Application for a Non-Material Amendment Following a Grant of Planning Permission

Development: Non-material amendment following grant of M/133/17/PL for removal of lantern light on rear conservatory and replace with 2 No. fixed skylights, finish external wall of conservatory in face brickwork and replace Cedral Lap system external wall cladding with Cedral click-plank system (no colour change)

Location: Little Thatch, Caravan 93 Middleton Road Middleton-On-Sea PO22 6DW

SHEET 1

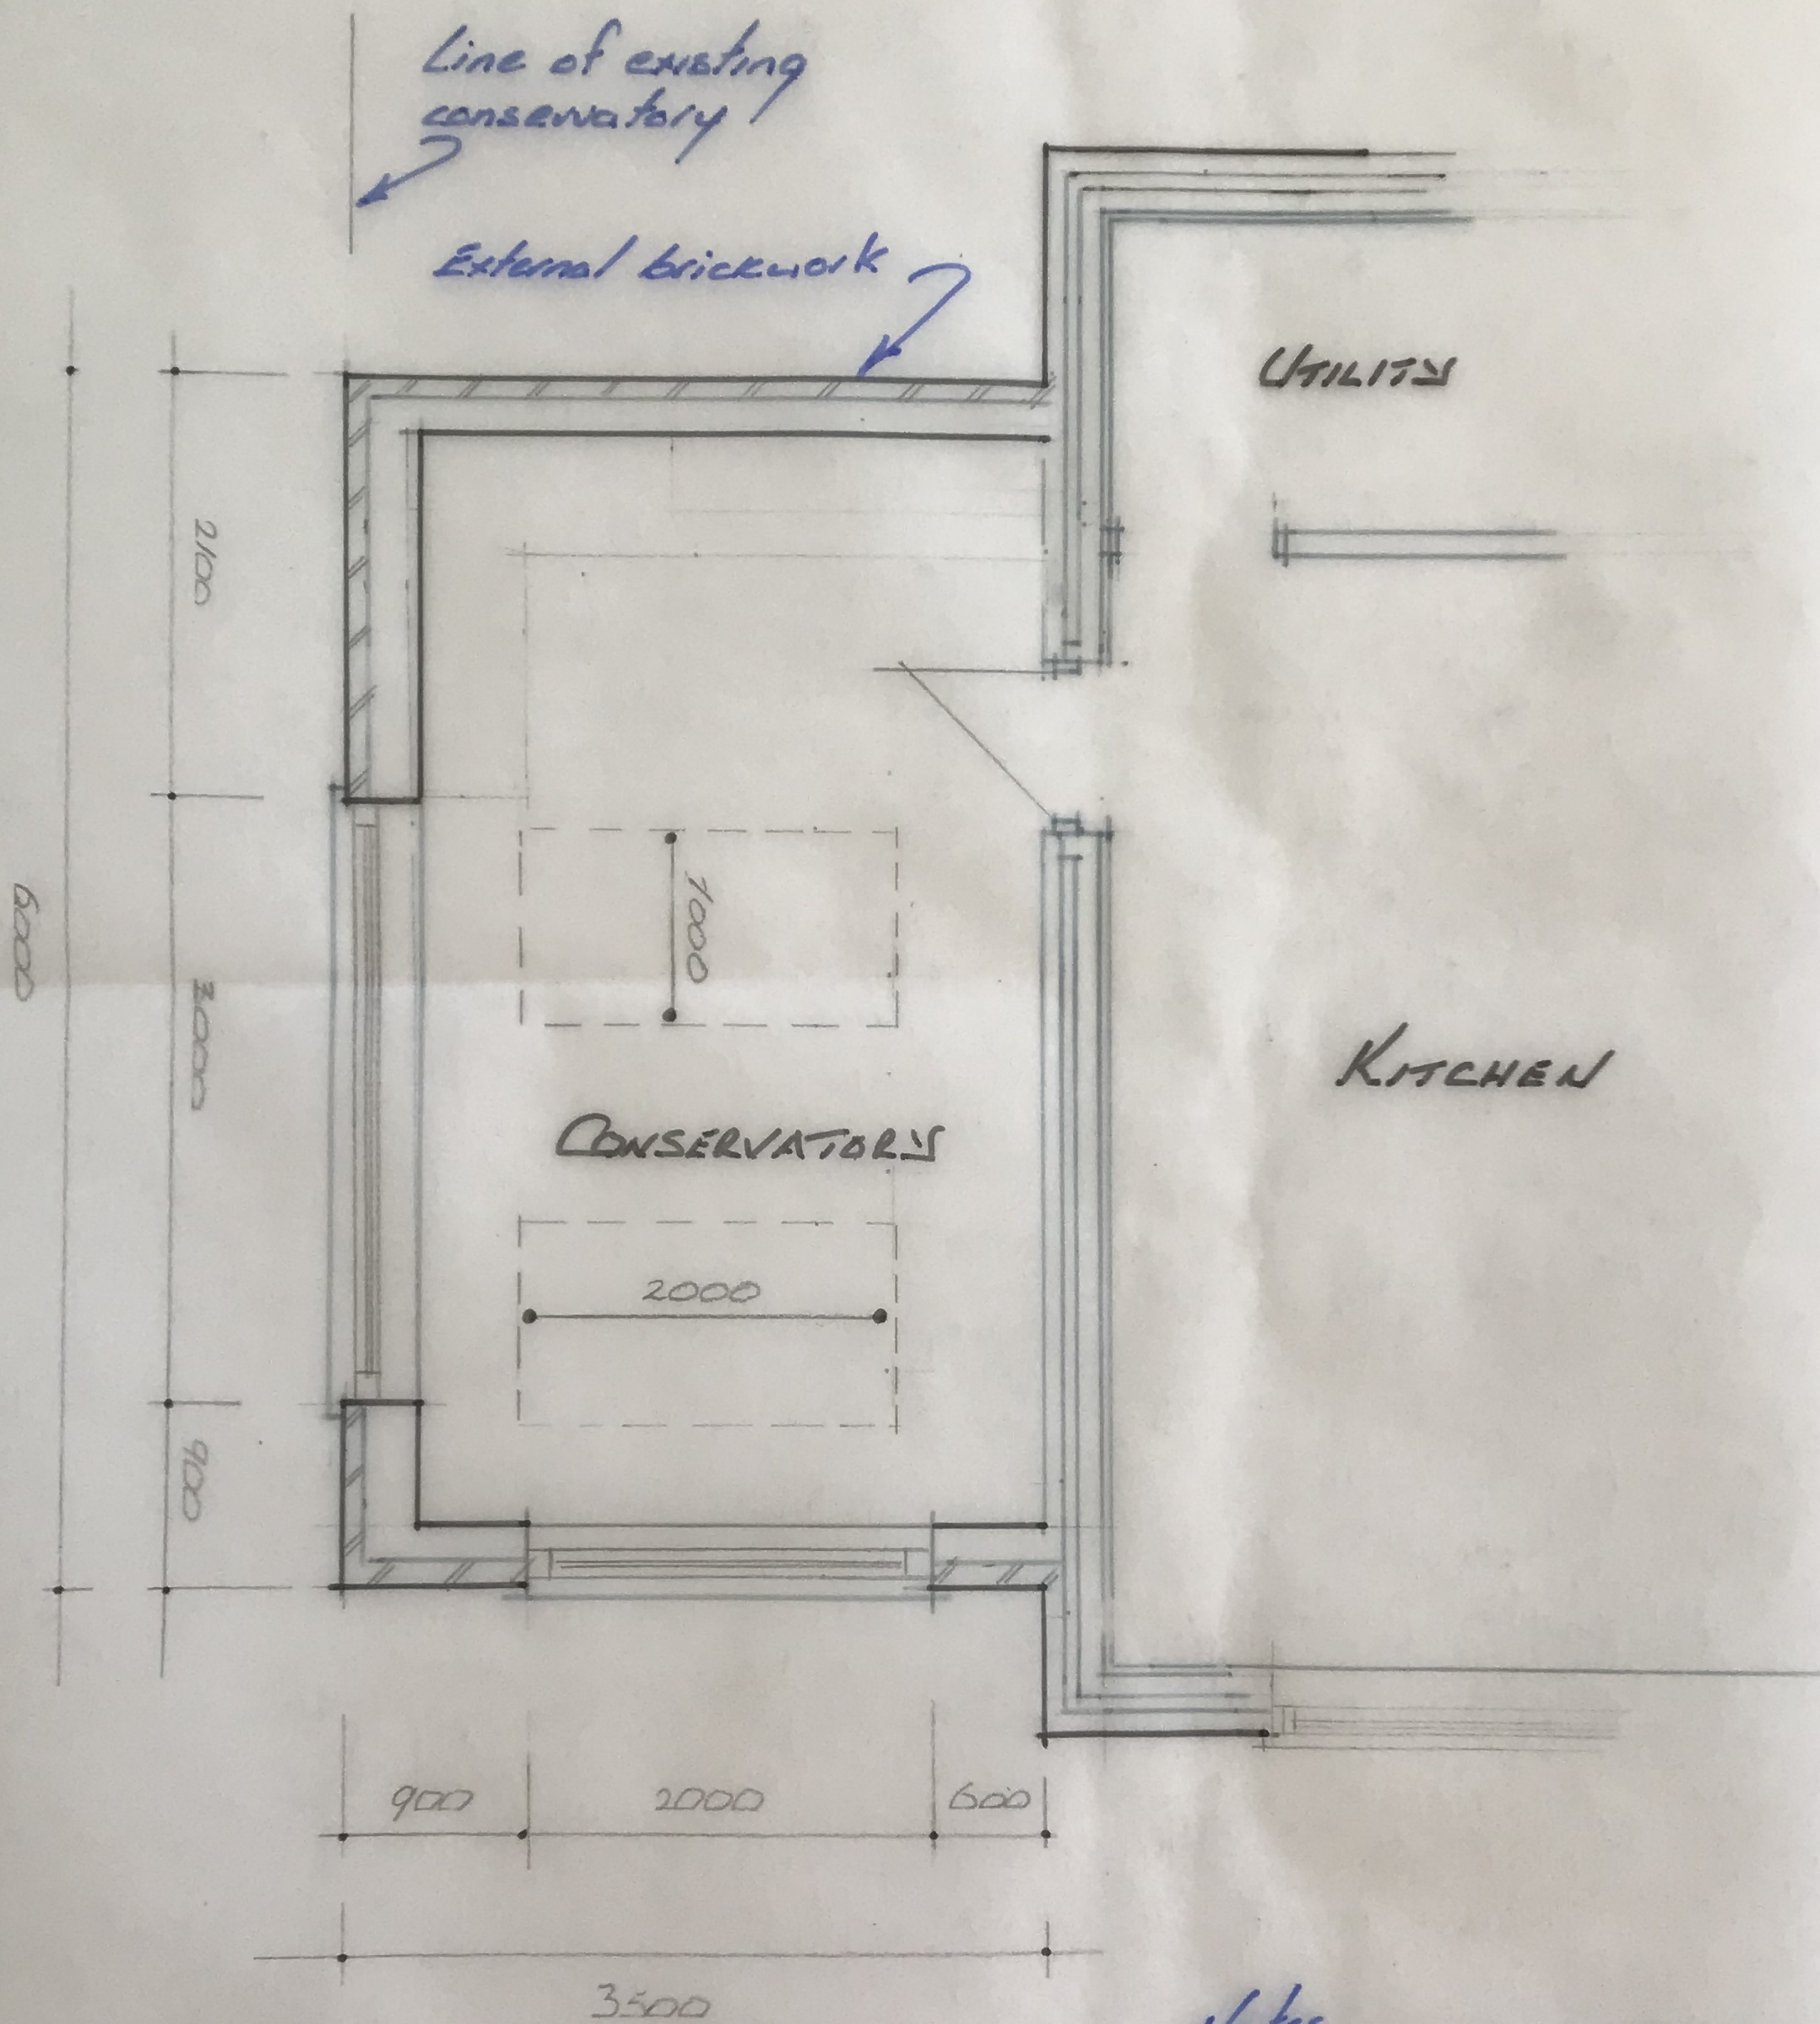
The plans submitted are not to scale. Please amend the plans to include all dimensions including the 2 No. skylights and remove the scales.

Please clearly label the plans to show the brickwork/cladding.
